DELEGATED DECISION TO DETERMINE PLANNING APPLICATIONS

Reference No:	2026/62/90957/E
Site Address:	Meadow Barn, 16, Manor Road, Farnley Tyas, Huddersfield, HD4 6UL
Description:	Erection of a freestanding greenhouse sited to side of dwelling (within a Conservation Area)
Recommending Officer:	Elenya Jackson

Officer Report

DRAWING TITLE  
**Proposed Elevations**

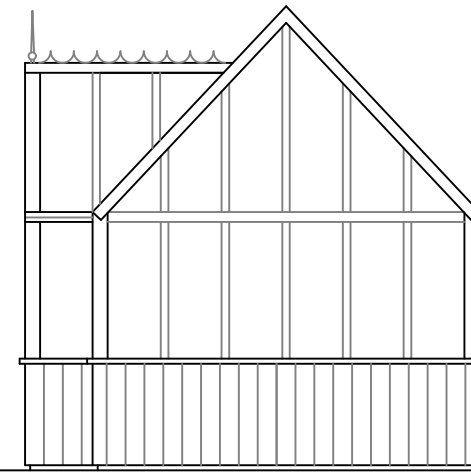
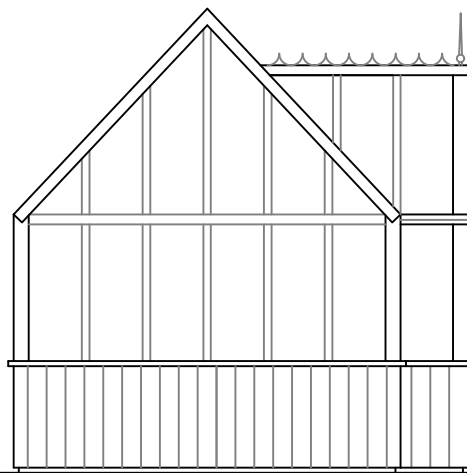
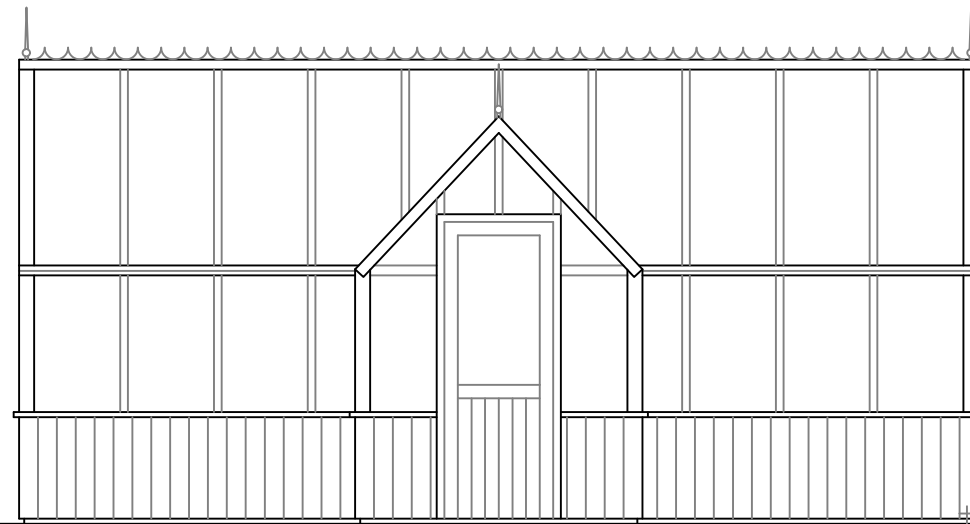
1. The application form describes the Greenhouse materials as "painted hardwood" but does not state the proposed colour. The colour should be specified and preferably be timber toned. In this prominent conservation area location, white should be avoided.

Officer Response: As a colour has not been specified for the timber frame of the Greenhouse, officers have added a condition in this instance; however, it is possible an alternative colour would also be considered appropriate and

3. Notwithstanding the approved plans, the proposed greenhouse shall retain a timber colour finish matching that used in the construction of the existing building. This colour shall be retained for the lifetime of the development and shall not be amended without prior agreement from the Local Planning Authority.
